Project: Great Wolf Lodge, Chesterton
Prepared by: David Lewis
Approved by: Phil Bell
Date: 19/02/2020

1.0 Introduction

- 1.4 This Technical Note has been prepared in response to the comments from the OCC and provides further details in relation to the sustainability of the site, shuttle bus provision, walking and cycling improvements, signage strategy and the effect of the development proposals on the wider highway network. In addition, this Technical Note provides a brief summary of the matters which have been agreed.

Middleton Stoney 1803047-17C.pdf

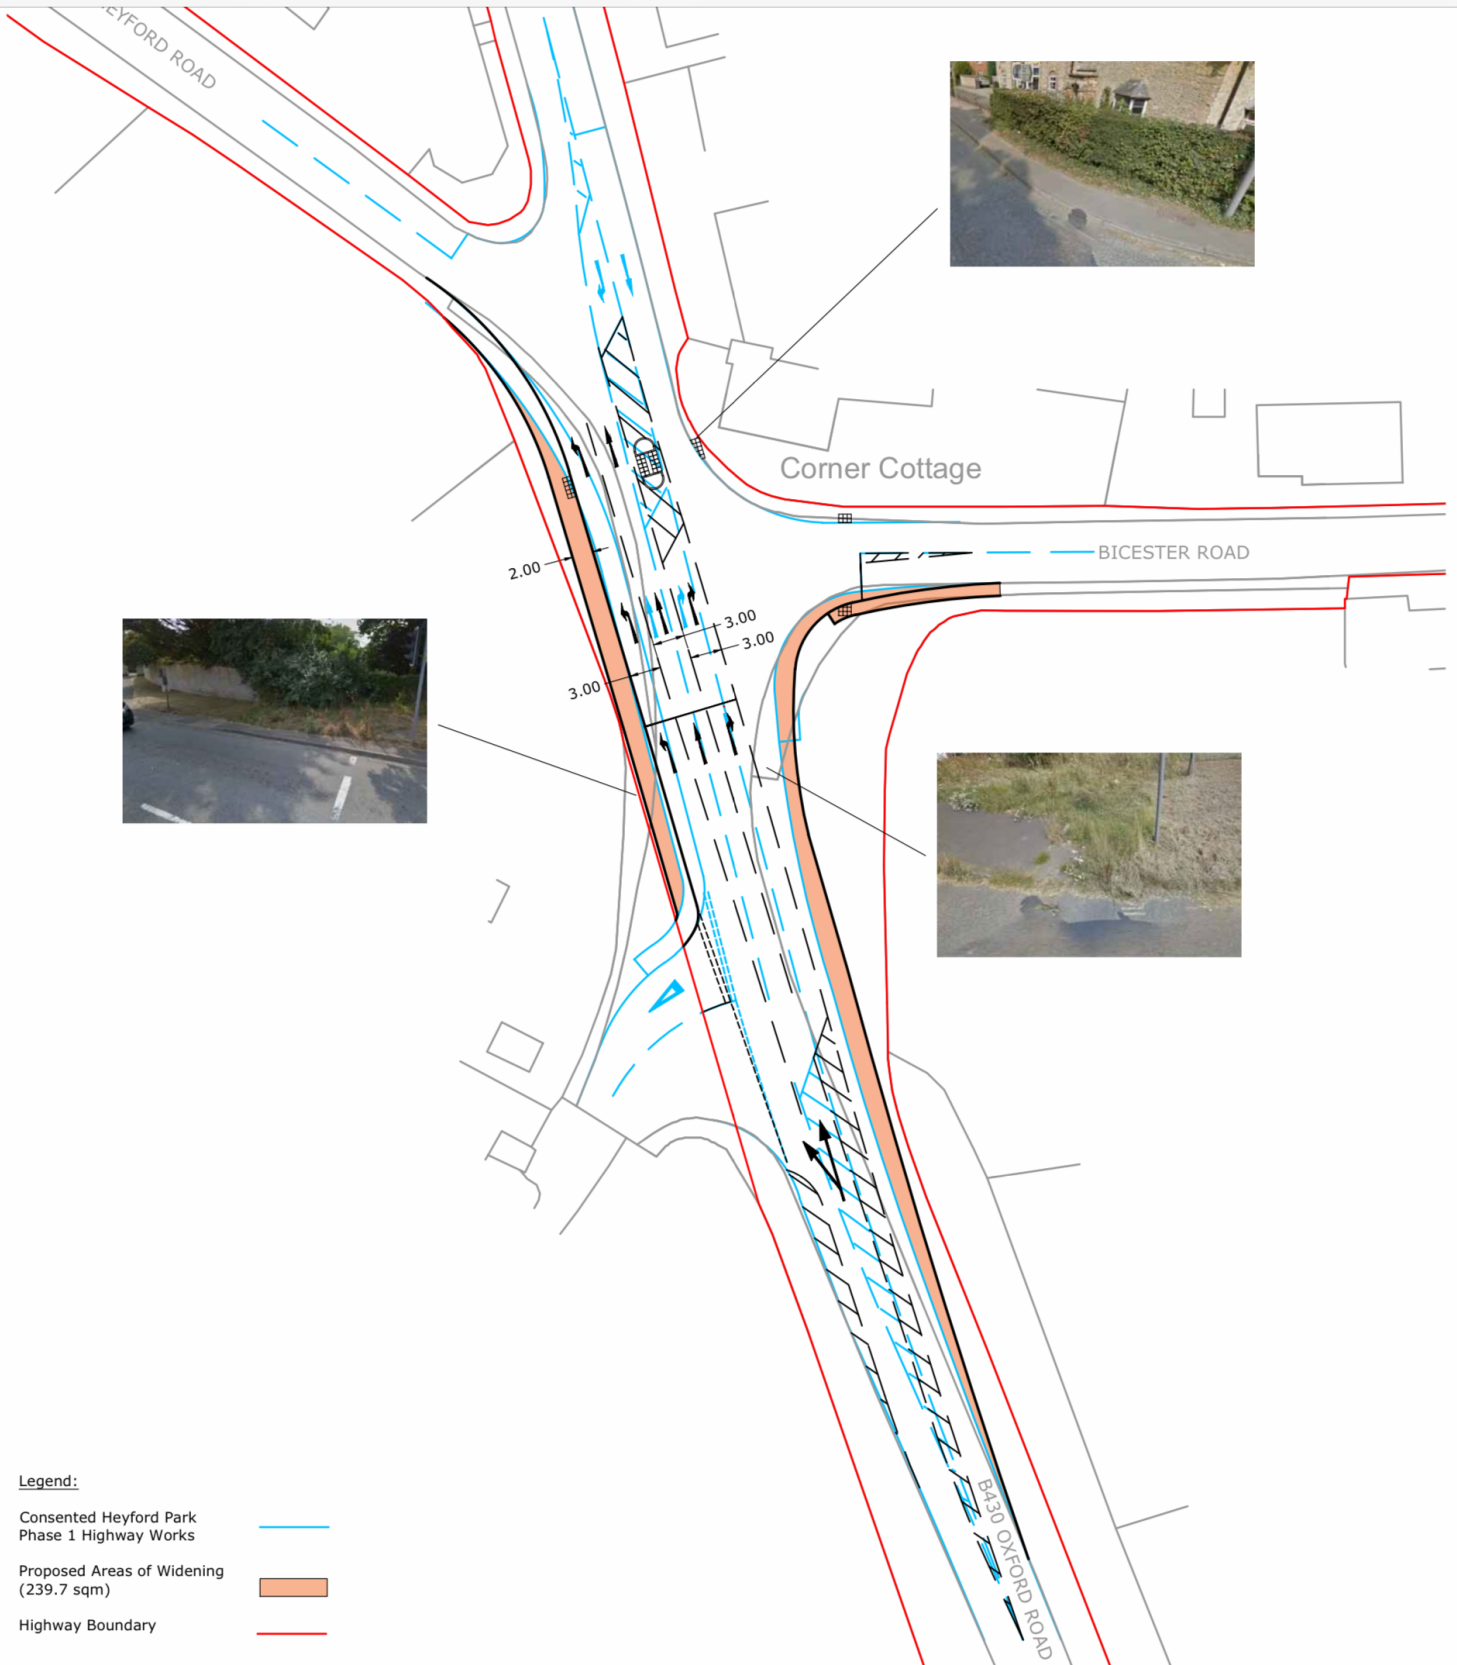
- 3.1 Motion are liaising with OCC regarding the effect of the development proposals on the local highway network, in particular, at the B430/ B4030 crossroads in Middleton Stoney. Motion maintain the position that the development proposals will not result in a significant change in vehicle movements at this junction. Notwithstanding this, further work is being undertaken in relation to the effect of the development at this junction and this could include further consideration of the signage strategy for the development.

Drawing:
1803047-03

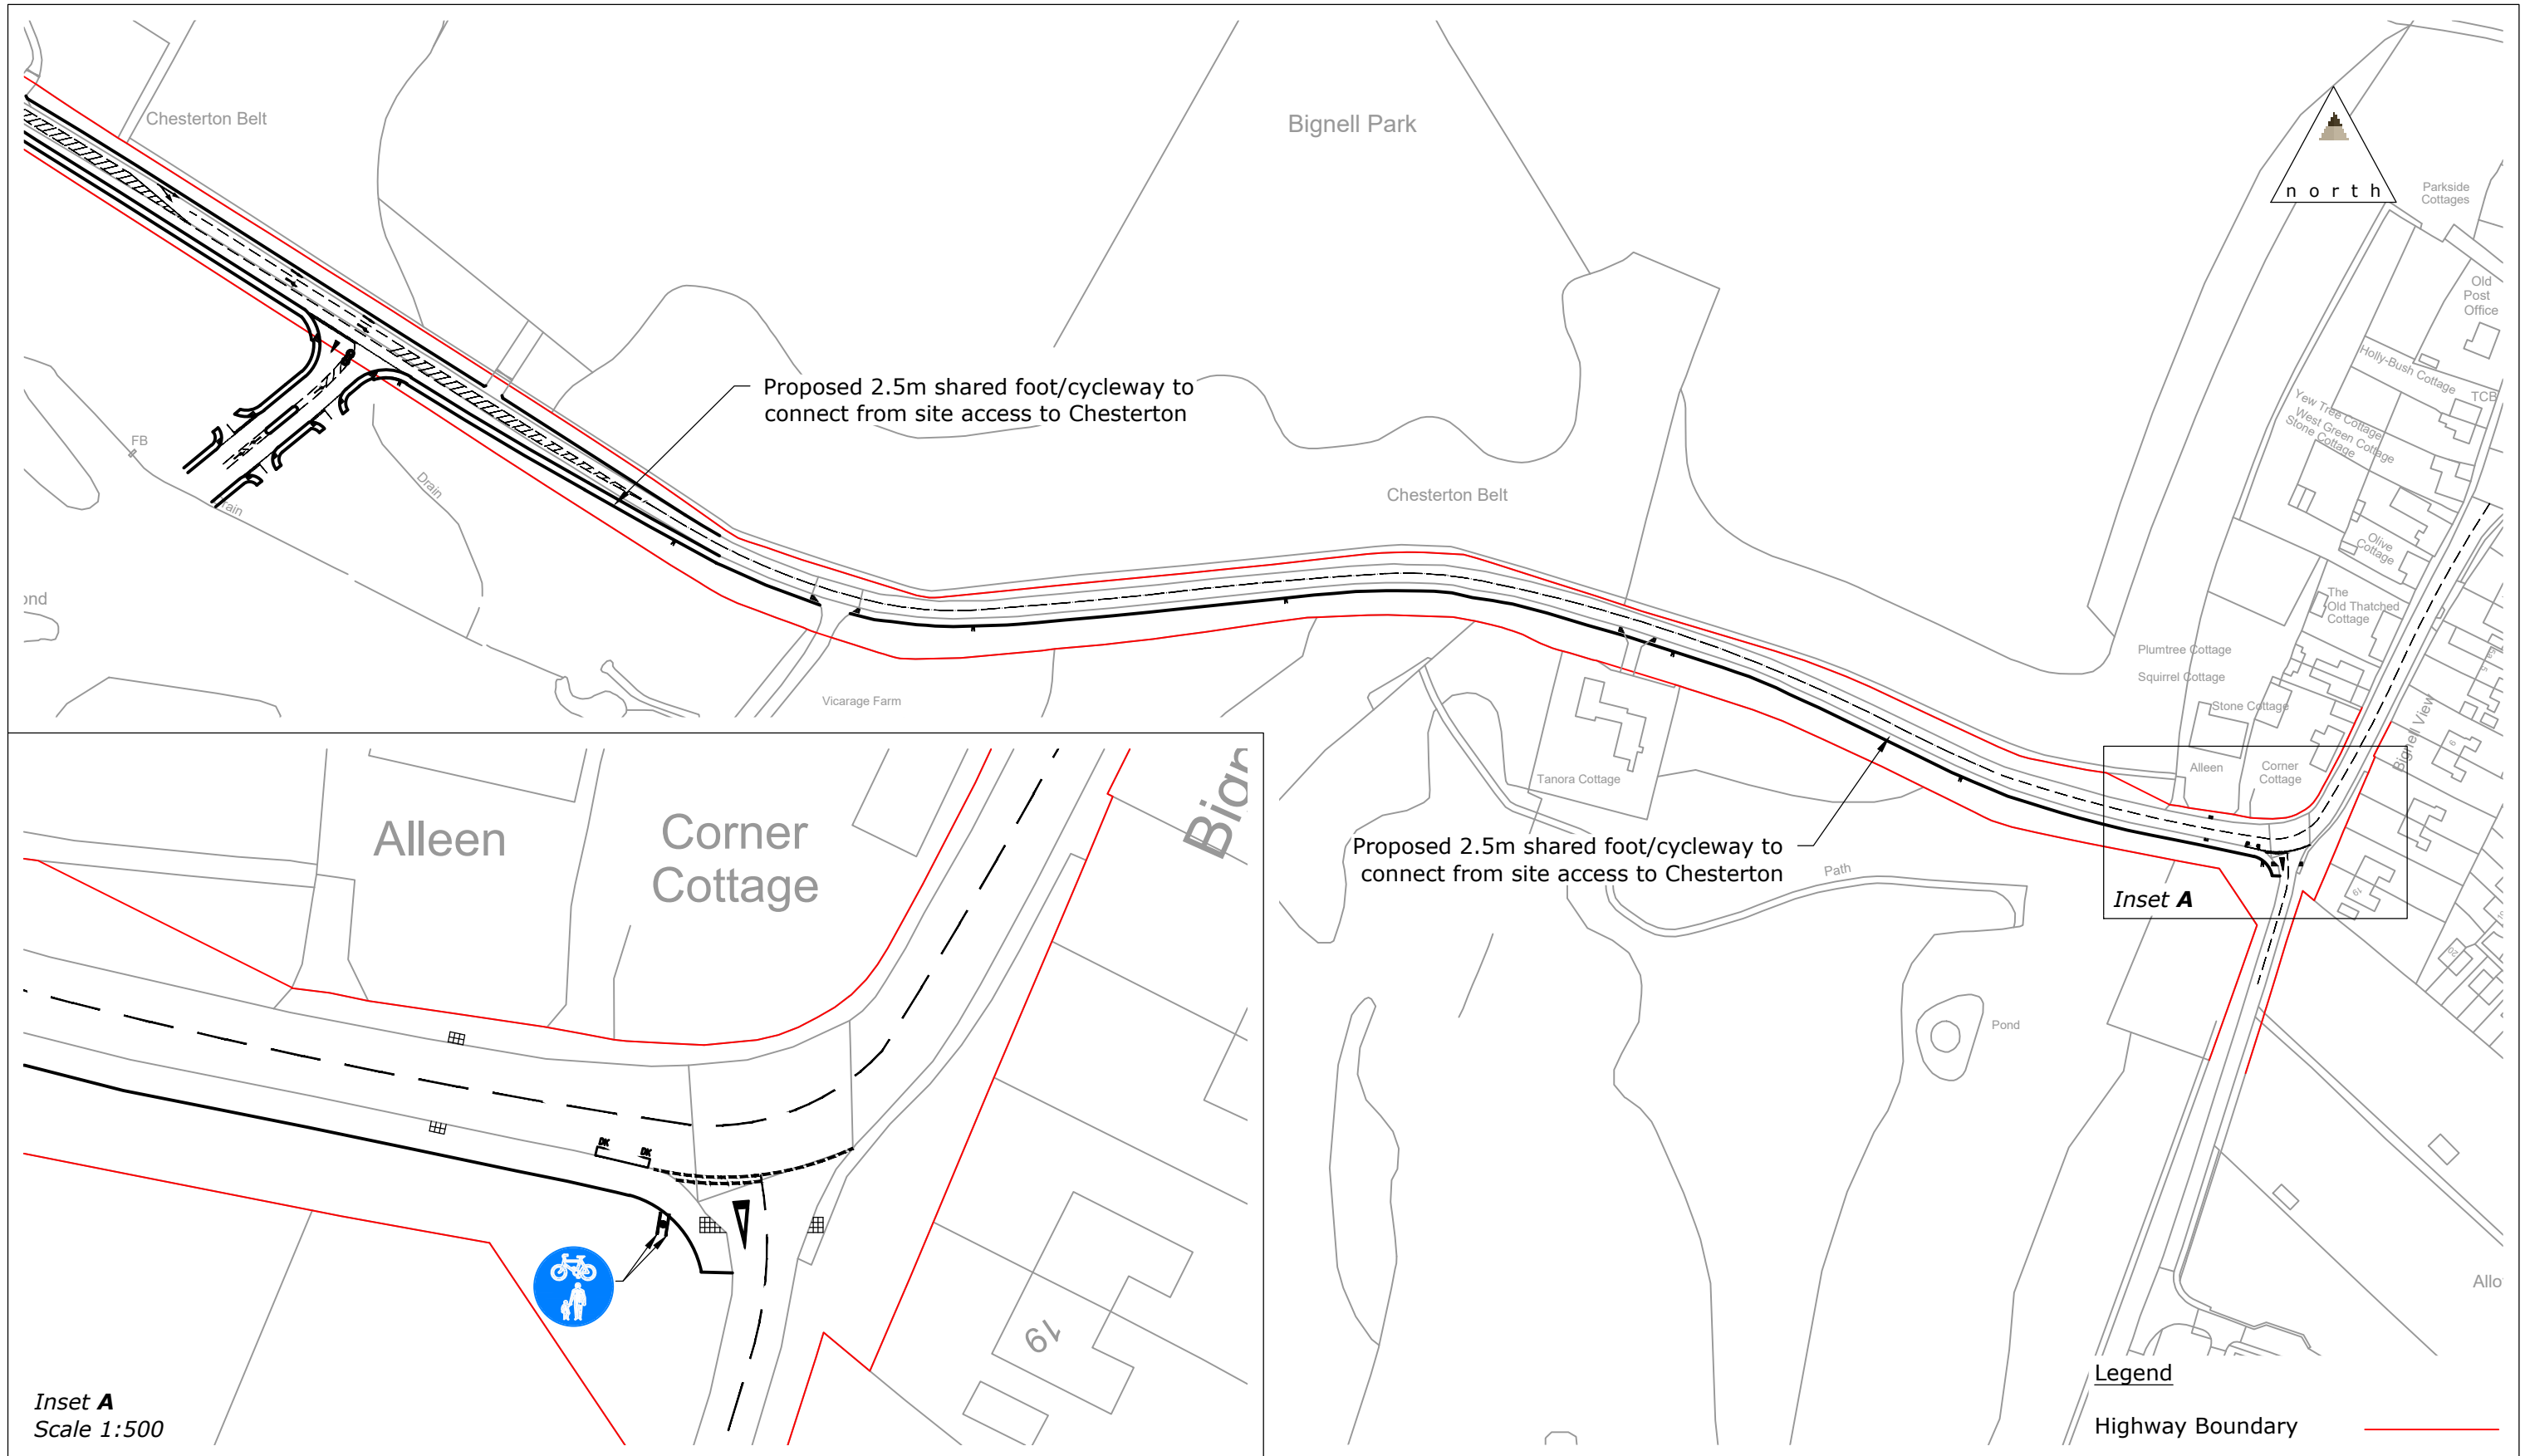
- 2.12 Following discussions with OCC it is now proposed that an additional stretch of footway of circa 370 metres in length is provided along the A4095 west of the site access junction, either side of the motorway overbridge, to connect with PRoW 161/11 to the west. This provides a betterment to the existing connection between PRoW 161/06 and PRoW 161/11, providing pedestrians with a footway where they are currently required to walk within the grass verge to connect between PRoW 161/06 and PRoW 161/11. The proposed extended footway is shown on Drawing 1803047-03, attached at [Appendix A](#).
